Subject: Mistletoe Farm Horsemere Green Lane Climping BN17 5QZ - CM/72/21/DOC

Planning Application Reference: CM/72/21/DOC

Proposal: Approval of details reserved by condition imposed under CM/18/21/PL relating to conditions 5-Biodiversity Enhancement plan, 7-covered and secure cycle storage, 8-electric vehicle charging space(s), 9-Energy Statement, 10-surface water drainage, 11-Arboricultural Assessment & 12-Construction Management Plan.

PROPOSED CAR CHARGING PLAN
(1:100)

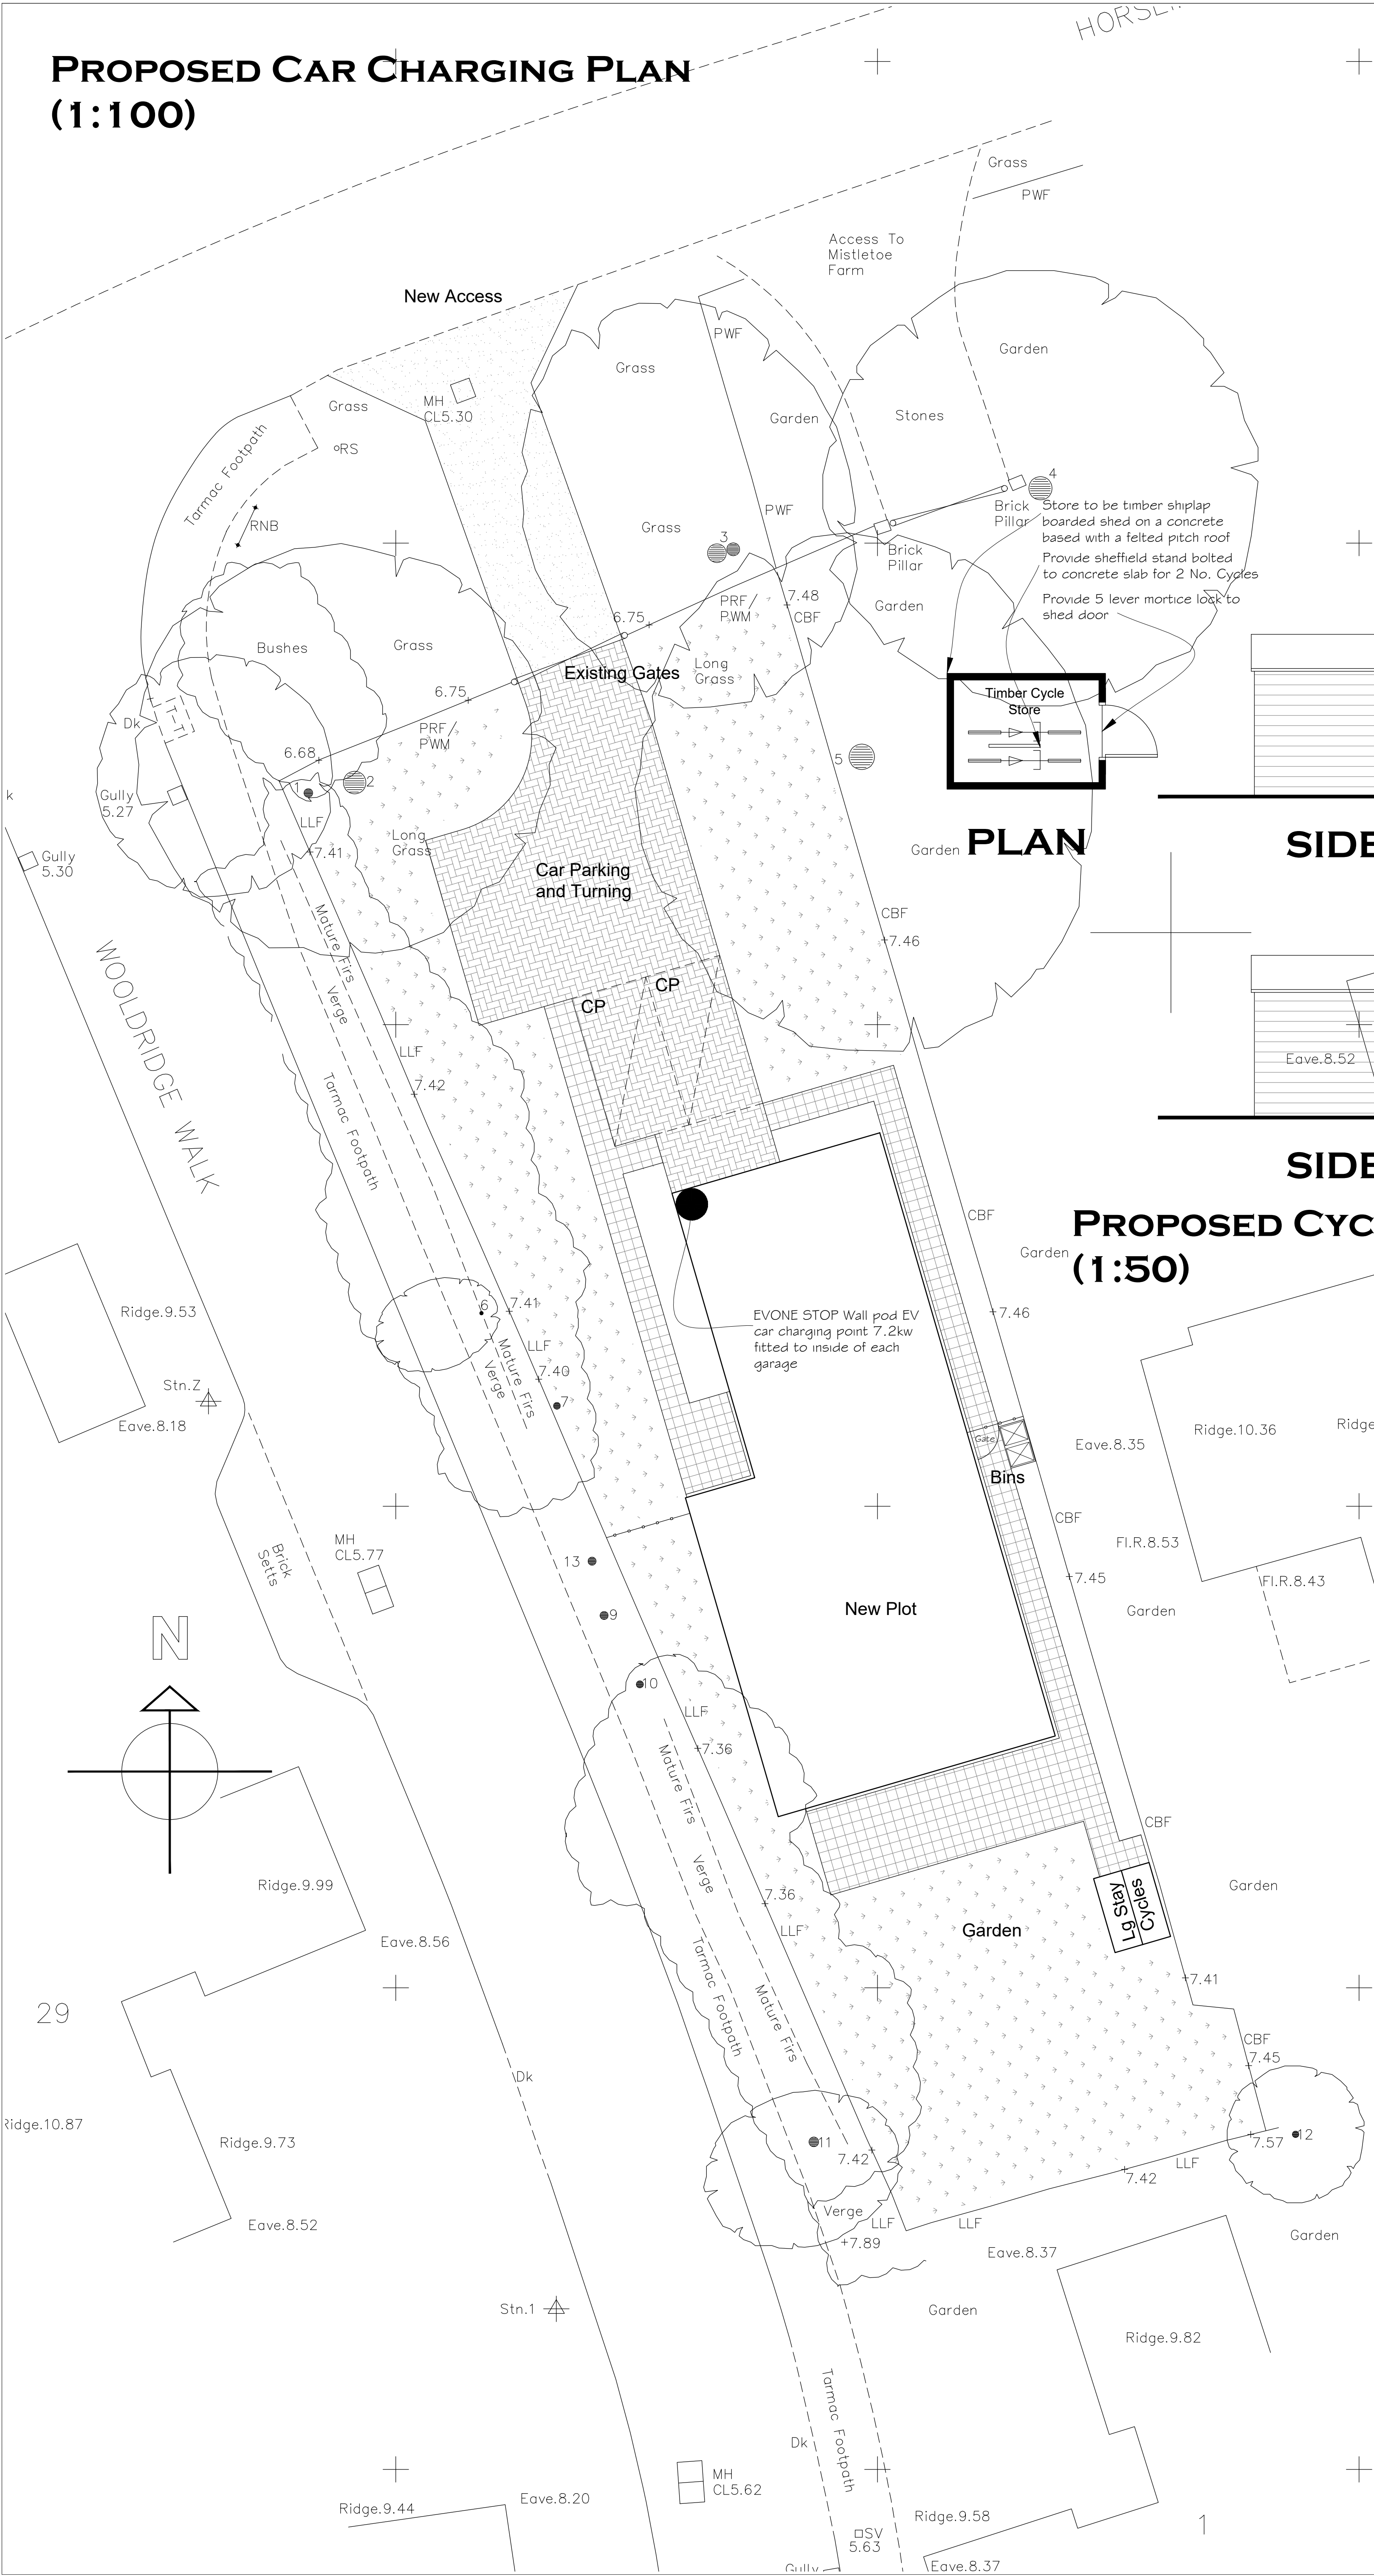
Having reviewed the document entitled 'Wallpod:EV | Free to use | Type 2, Mode 3 Charging Socket 3.6kW or 7.2kW'. I note the product codes to include EVWP 2010, EVWP 2016, EVWP 2020, EVWP2026. These models do not appear on the governments database of electric vehicle home charge scheme approved model list. As the model does not appear on the home charge list this indicates the proposed model is more suited to commercial applications. I therefore request the applicant provides a model which appears on the government database of electric vehicle home charge scheme approved model list.
